## WEST SUSSEX COUNTY COUNCIL CONSULTATION

| <b>LOCATION:</b>                | 6 Selborne Road<br>Littlehampton<br>BN17 5NH                                                                                                                                                                                                                                                                                                                                                             |
| <b>SUBJECT:</b>                 | LU/163/20/PL<br><br>Demolition of existing conservatory, single storey front & rear extensions & change of use from HMO (Sui Generis) to 5 No. flats (4 net) (C3 Dwelling house). This application affects the character & appearance of the Littlehampton Seafront Conservation Area & may affect the setting of a listed building. This application is not CIL Liable as flats in Zone 4 (Zero Rated). |

drawing title
Proposed Plans
-
PLANNING

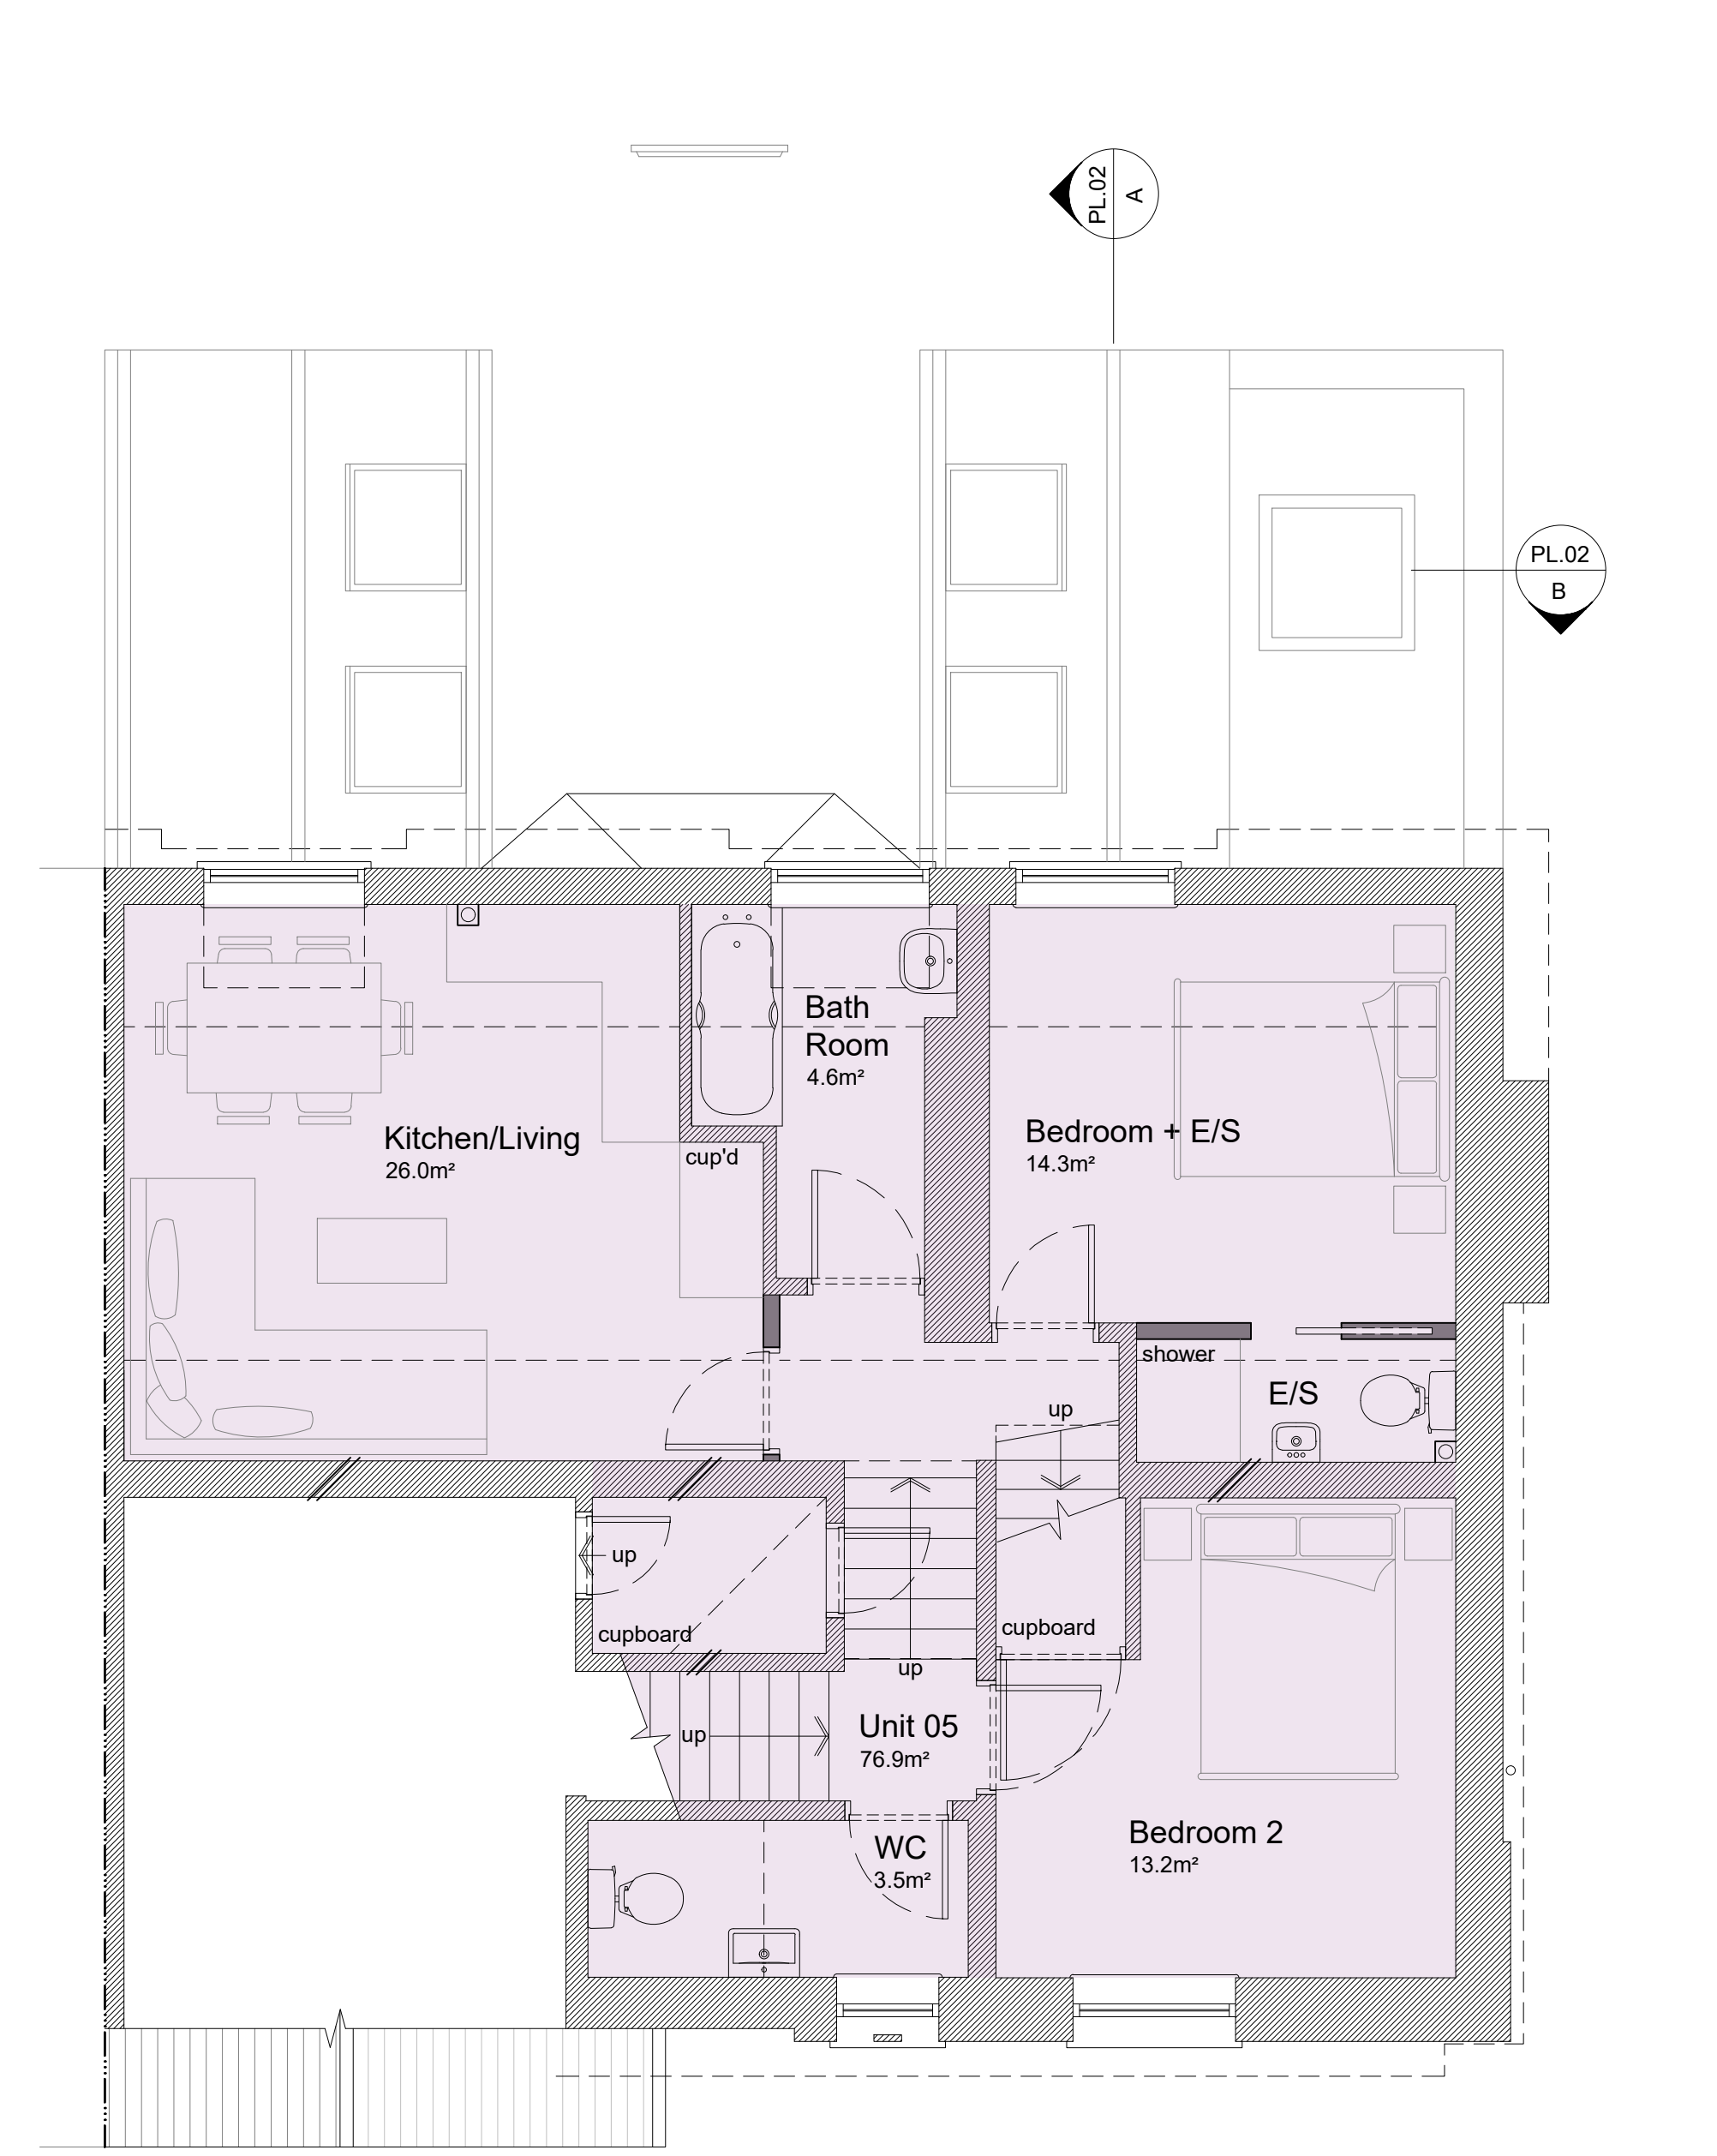
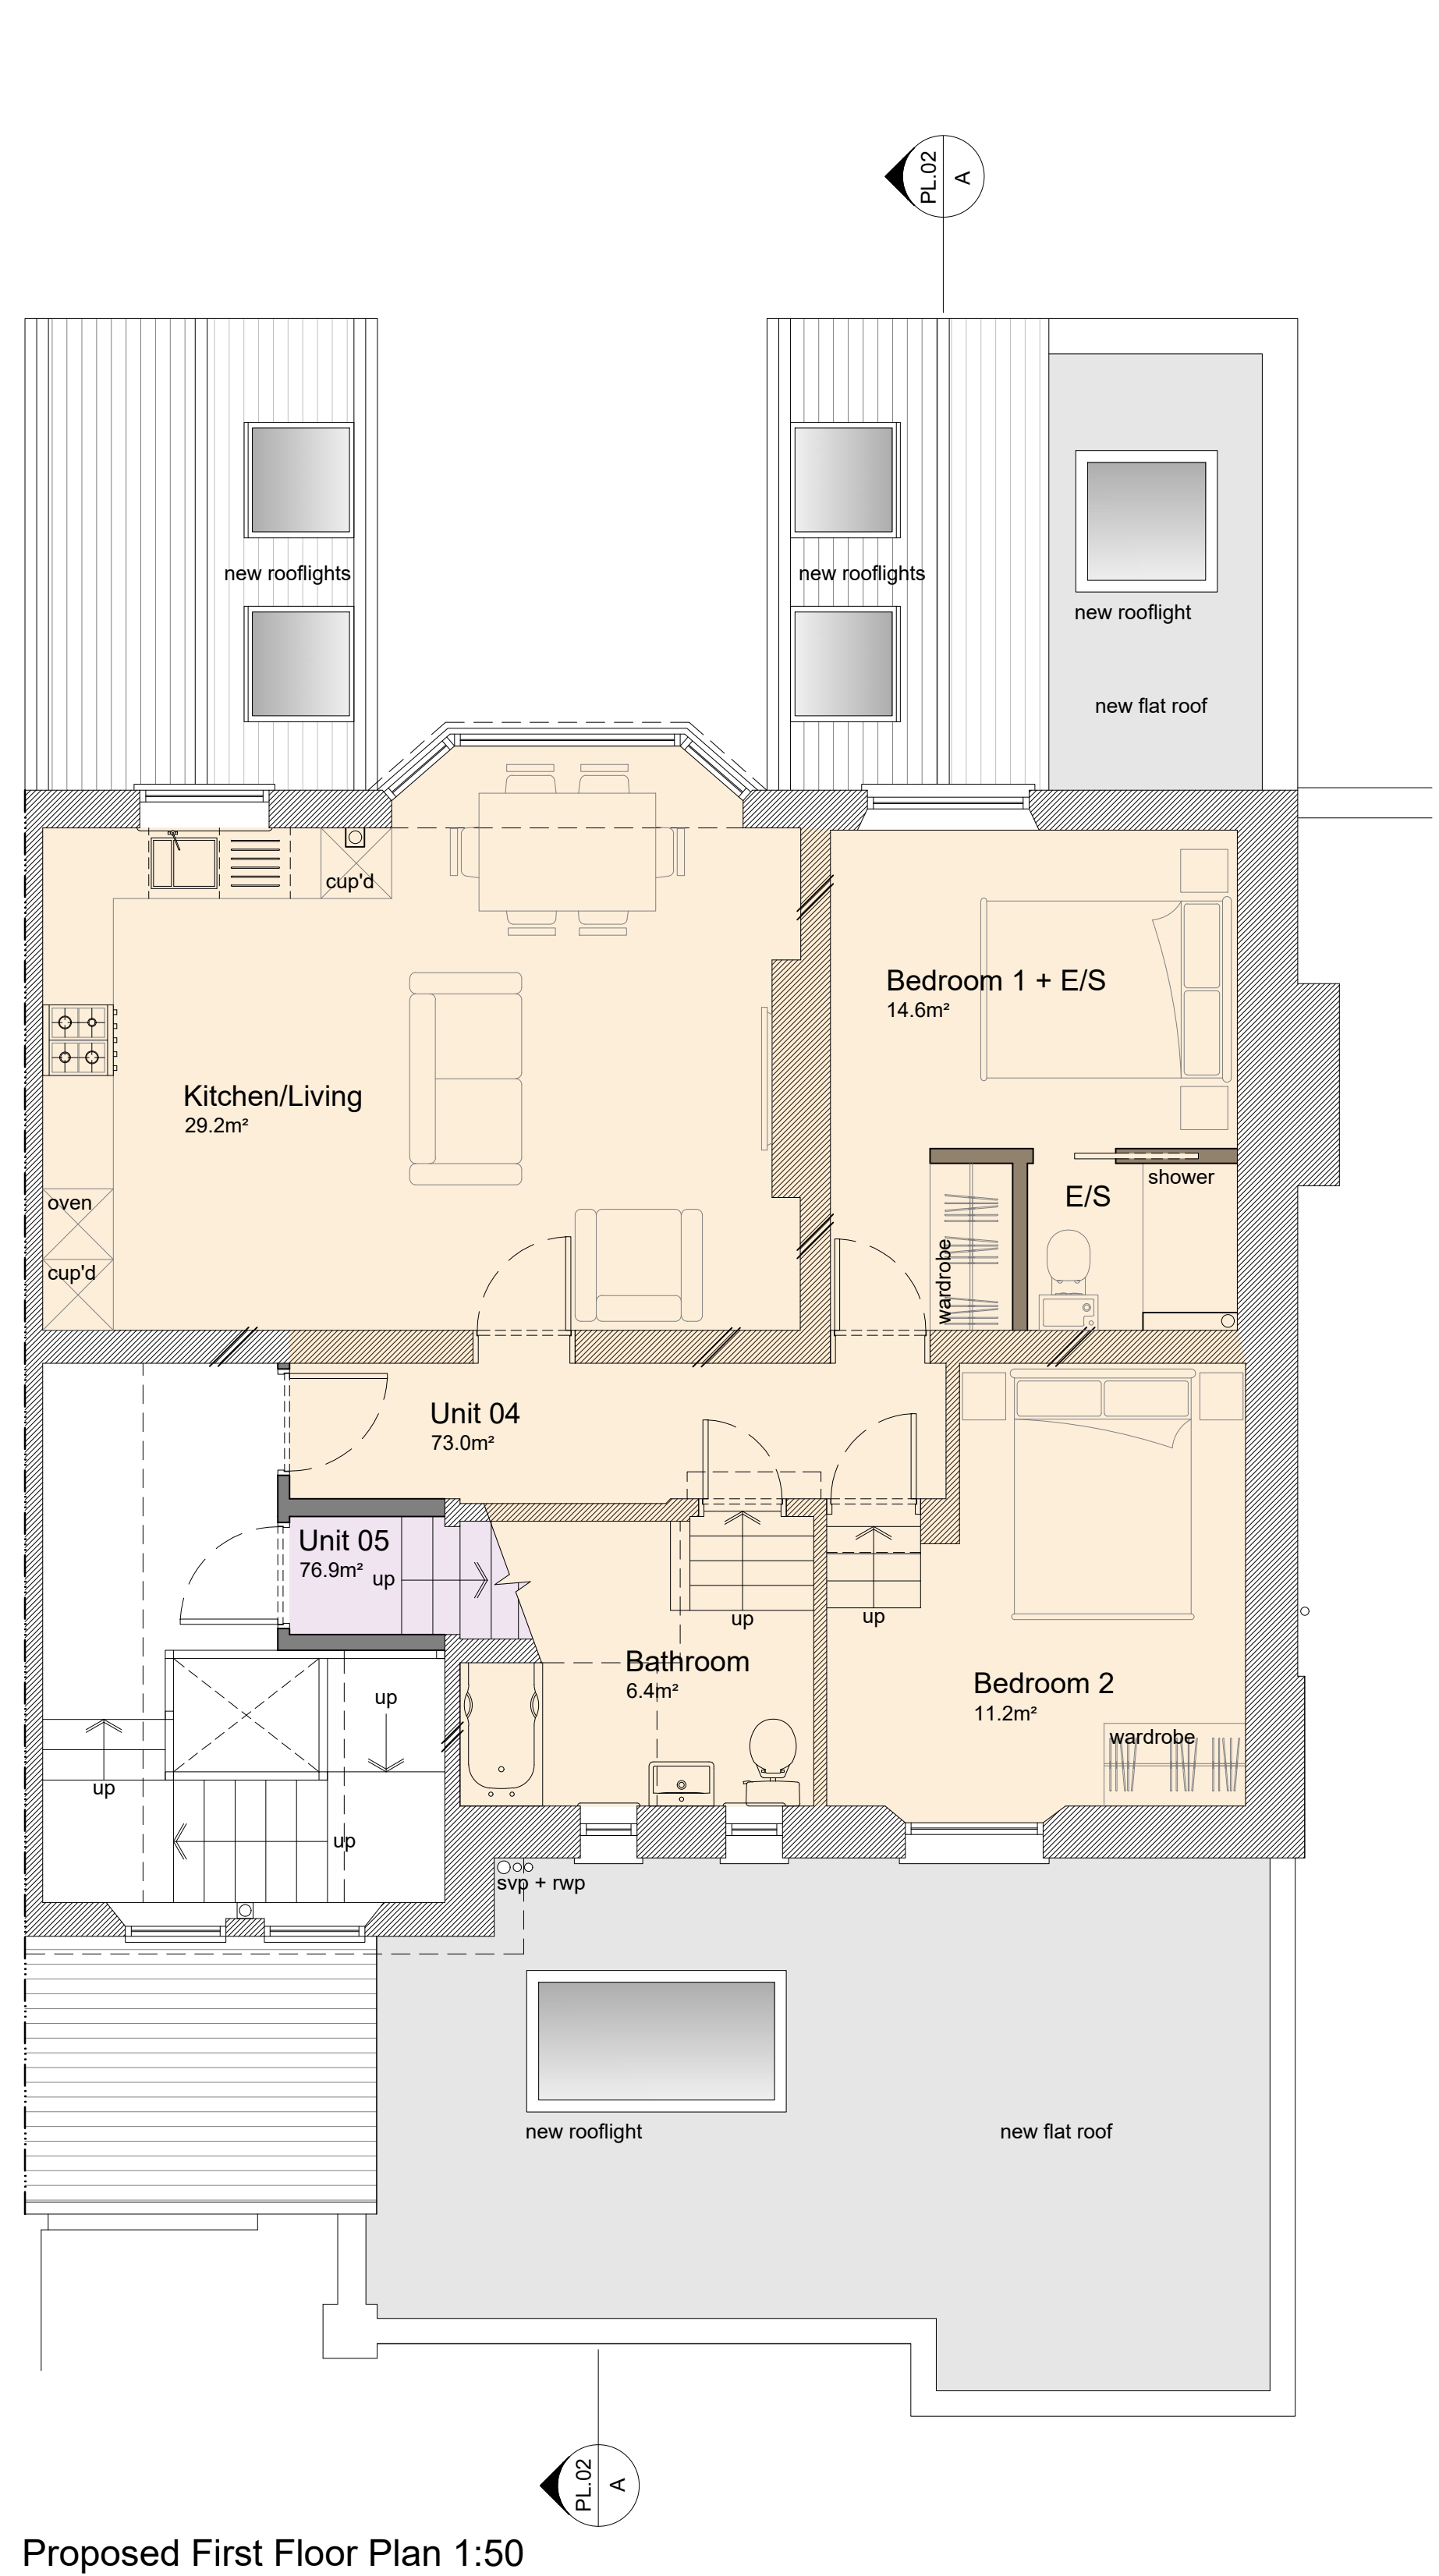
The applicant has not specifically demonstrated the existing/proposed parking provision, but it seems that the existing hardstanding parking area could likely accommodate circa 4 – 5 vehicles. I note that the proposed block plan details refuse and recycling within the existing hardstanding, it is anticipated that this could be provided in a more efficient space to retain all available on-site parking provision.

I would be minded to advise a condition securing the layout and demonstration of the parking provision so it can be secured in perpetuity, ideally on an unallocated basis. The LPA and applicant may wish to resolve this matter prior to determination.
